**A303 Sparkford to Ilchester Dualling
PINS Reference: TR010036**

**Joint Council Local Impact Report
23rd January 2019**

**Submitted by South Somerset District Council and
Somerset County Council**

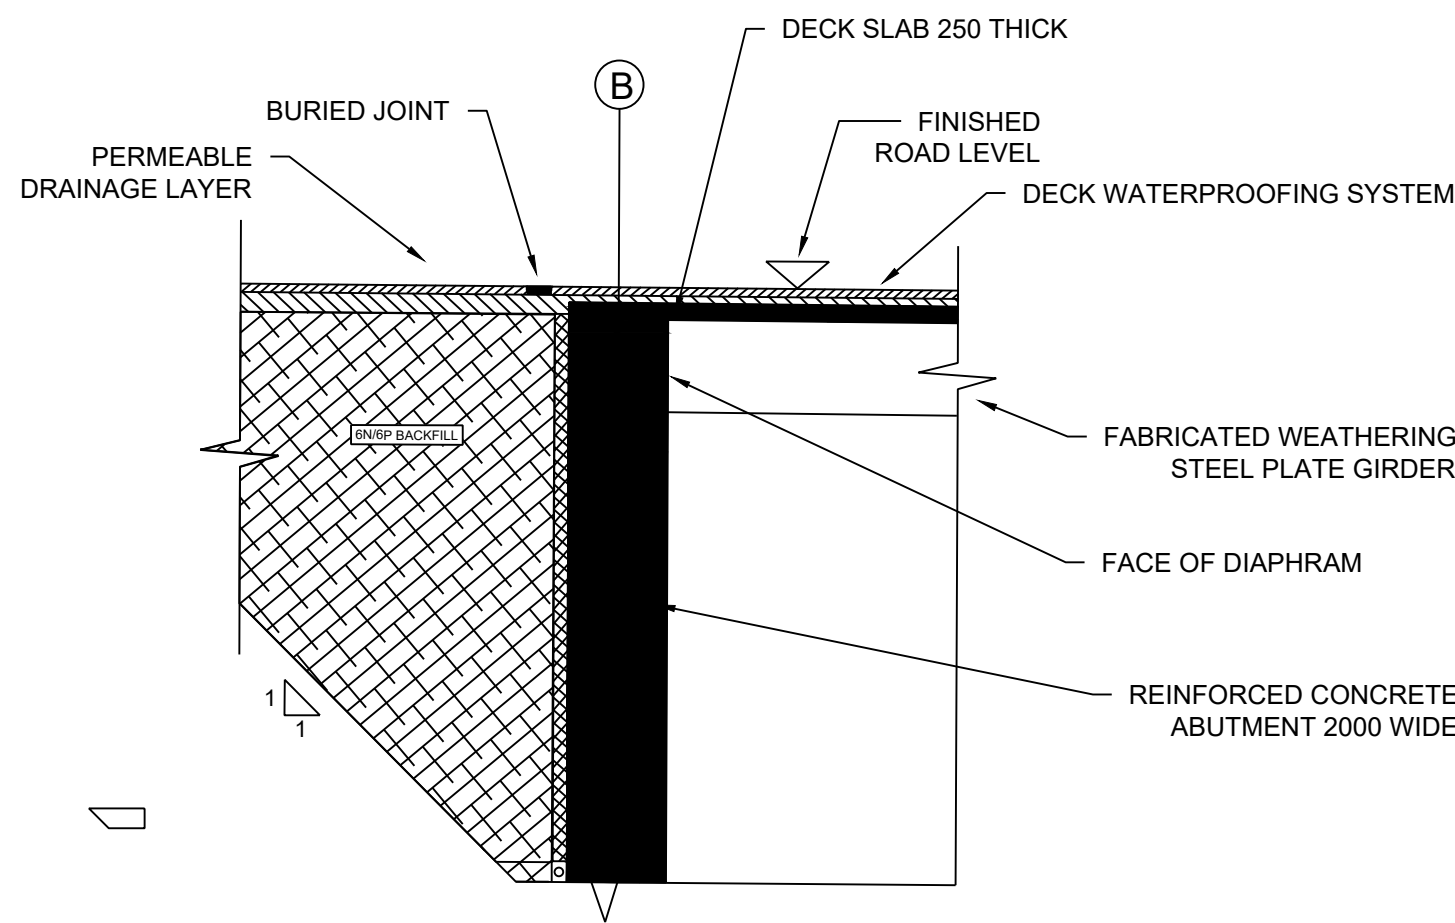
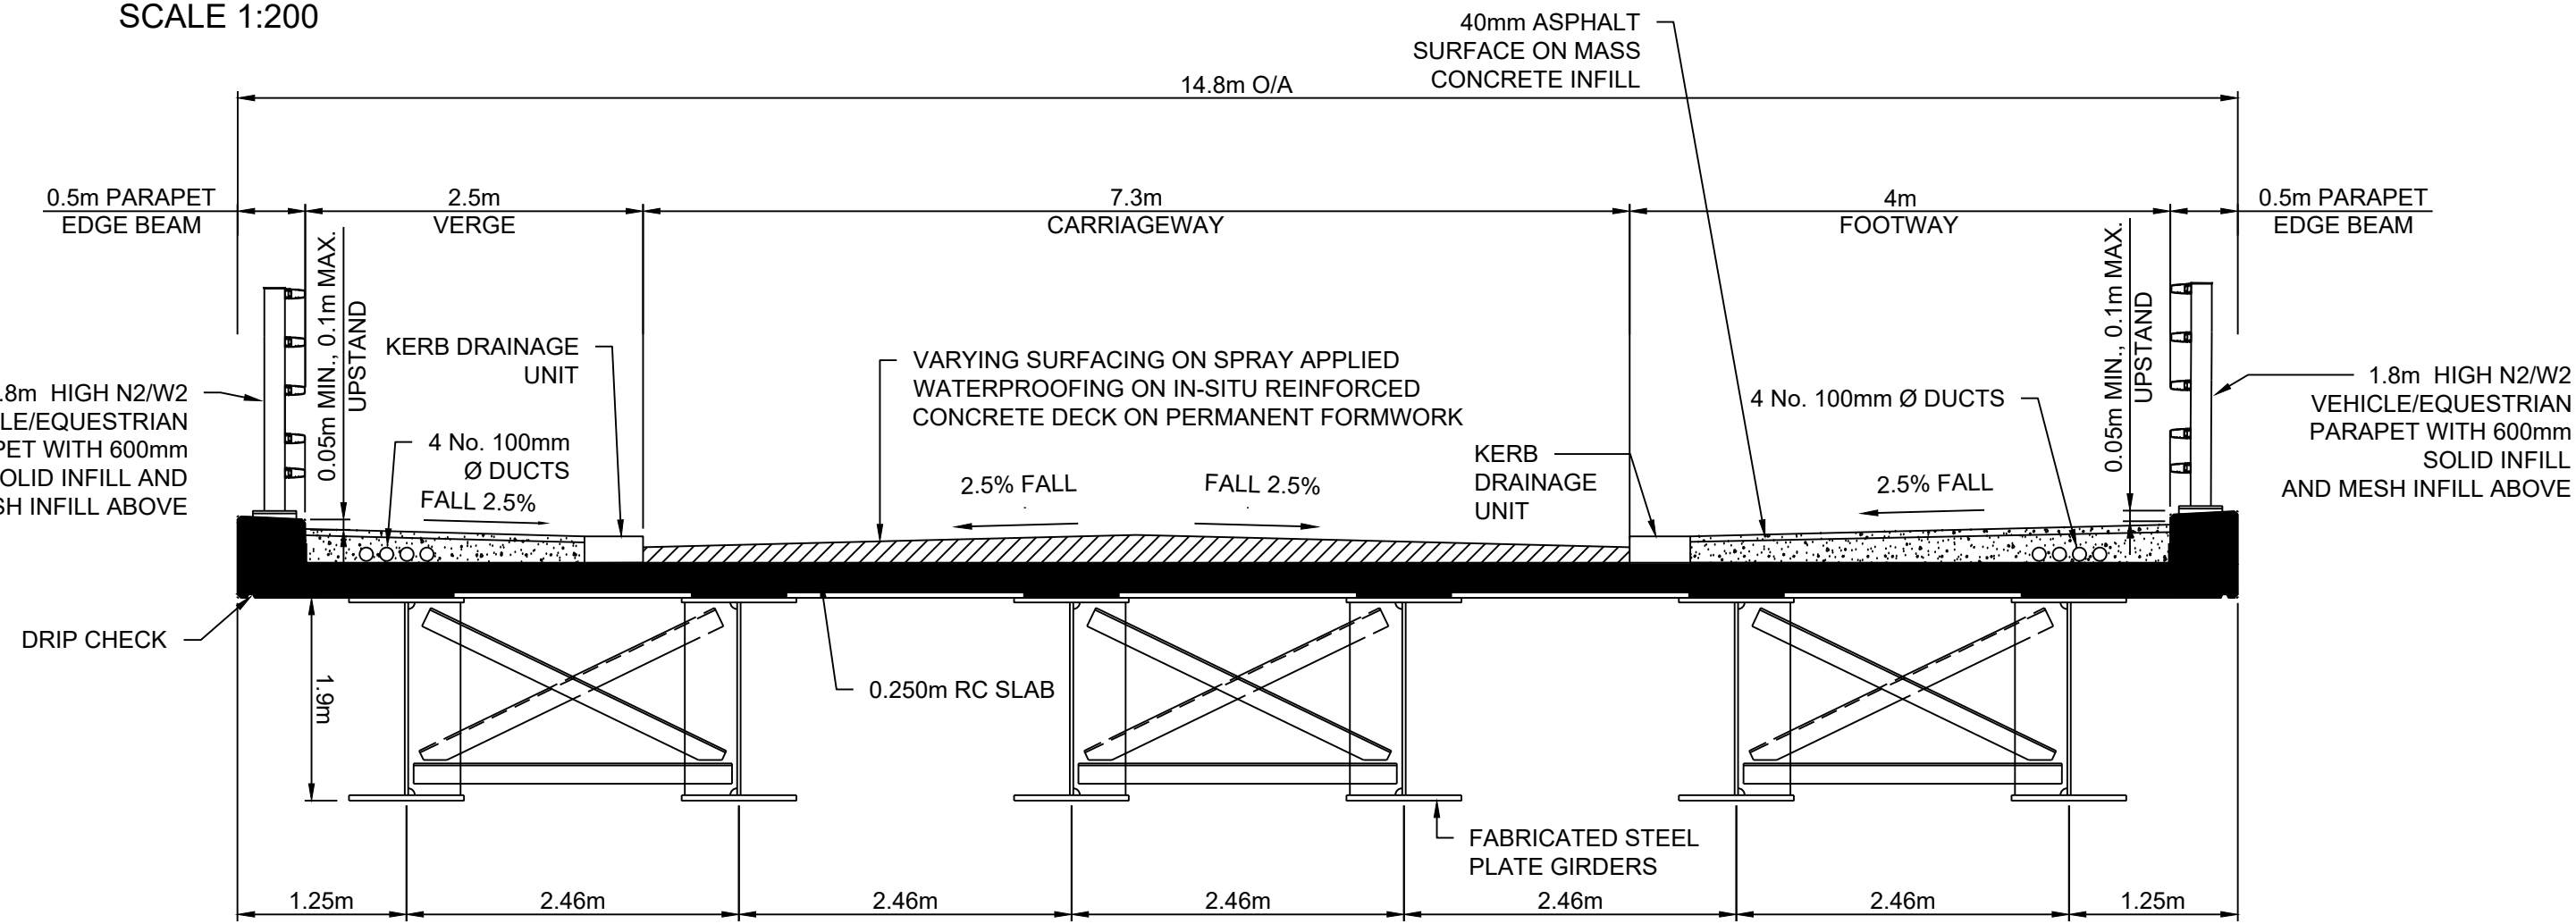
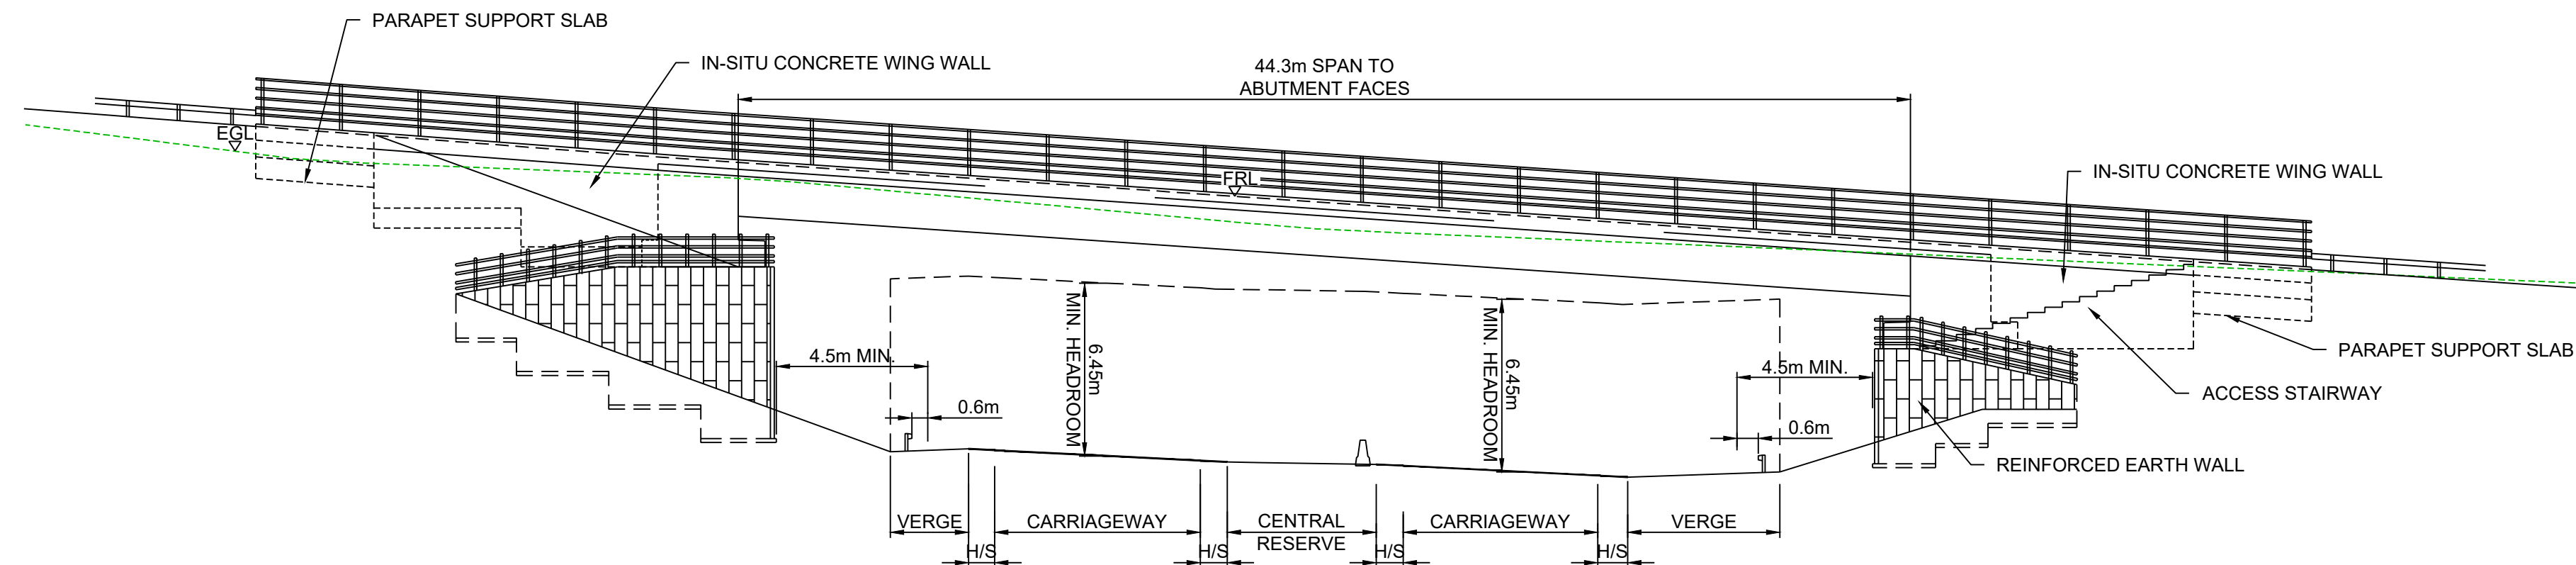
Link to EC12				
T3	<u>Structures</u> Design Phase: To date, the applicant has not submitted proposals in sufficient detail to enable the local highway authority to confirm whether any structures will be required within the extent of the local road network. The current version of the DCO indicates that where a structure is present within the LRN the LHA will adopt from its completion. SCC are concerned that the DCO as currently drafted does not include provision to allow SCC as the Local Highway Authority to approve detailed design matters as they relate to the Local Road Network (LRN). Requirement 12 as currently drafted provides that the local highway authority will only be <i>consulted</i> on detailed design matters which are not compatible with the preliminary design. Maintenance Phase: The current wording within the DCO does not reference any maintenance period post completion of the highway works, (including structures) and prior to new network becoming incorporated into the local road network. These sections include links to be de-trunked, where alterations to the existing network are proposed and the sections of new carriageway construction are outlined. It is essential that provision is made within the DCO for SCC to receive the necessary commuted sum payments for structures or other non-standard assets that require future capital maintenance as a result of the detailed design. To date, the applicant has not submitted design proposals to confirm if highway infrastructure is proposed that will, under normal circumstances require a commuted sum. Provision is needed within the DCO requiring the undertaker to pay any necessary commuted sums for structures to be adopted by SCC. The value of the commuted sum to be calculated by SCC.		The DCO is to be amended to include provision for SCC as the Local Highway Authority to approve the relevant detailed design matters where structures are proposed within the extent of the local road network. The DCO should include provision for a minimum 12 month maintenance period to be provided between the date of completion of the structures and their incorporation into the local road network. As per the provision currently outlined in 13(3). The DCO should include a provision to enable SCC to attract commuted sum payments for highway infrastructure requiring extra over maintenance.	NPSNN Para 4.20 (as above)	Design Amend Requirement 12 to enable detailed design by review / approval by SCC. Maintenance Provide a mechanism(s) that ensures a minimum maintenance period of 12 months and the provision of commuted sum payments to LHA where structures, and other non-standard assets, are offered to the LHA for adoption as a result of the scheme.

Appendix 1 APPROPRIATE MITIGATION FOR STOPPING UP OF TERMINUS OF BRIDLEWAY Y 30/28 (EASTMEAD LANE)

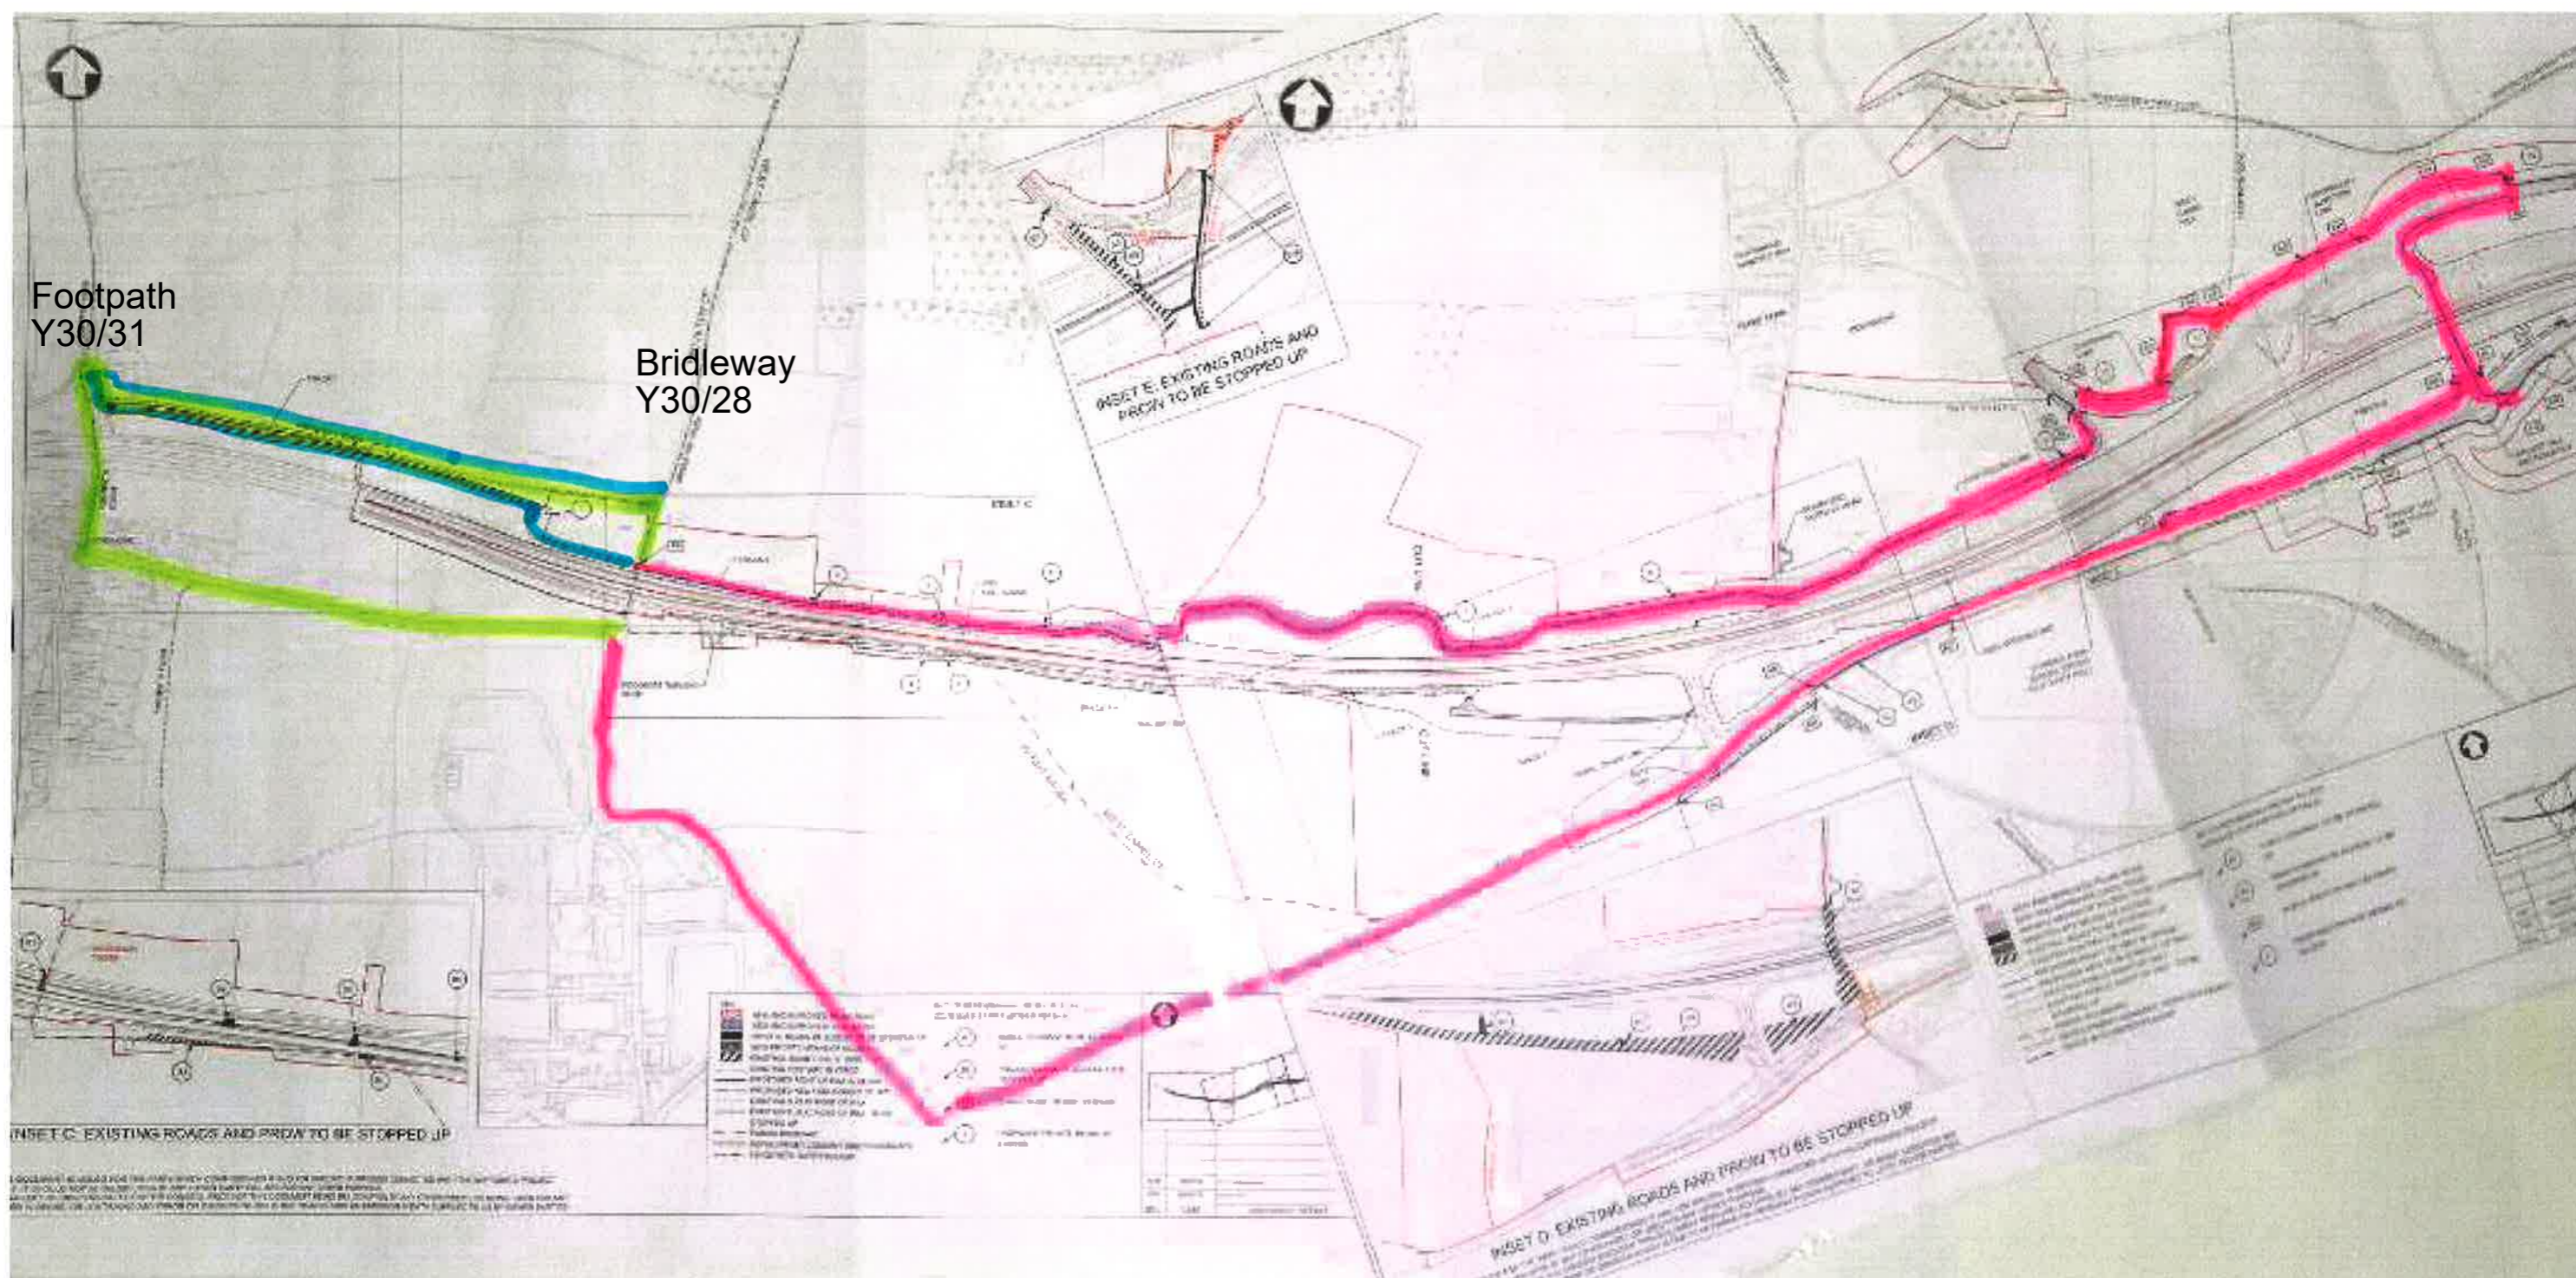
Concerns remain in respect of mitigation currently proposed by the applicant for the impact of the stopping up of the connection of Y30/28 with the A303. SCC has an alternative mitigation proposal which is considered to be more convenient and shorter in length for affected users. SCC has also raised concerns about how consideration is given to unrecorded rights that may exist which the development could interfere with.
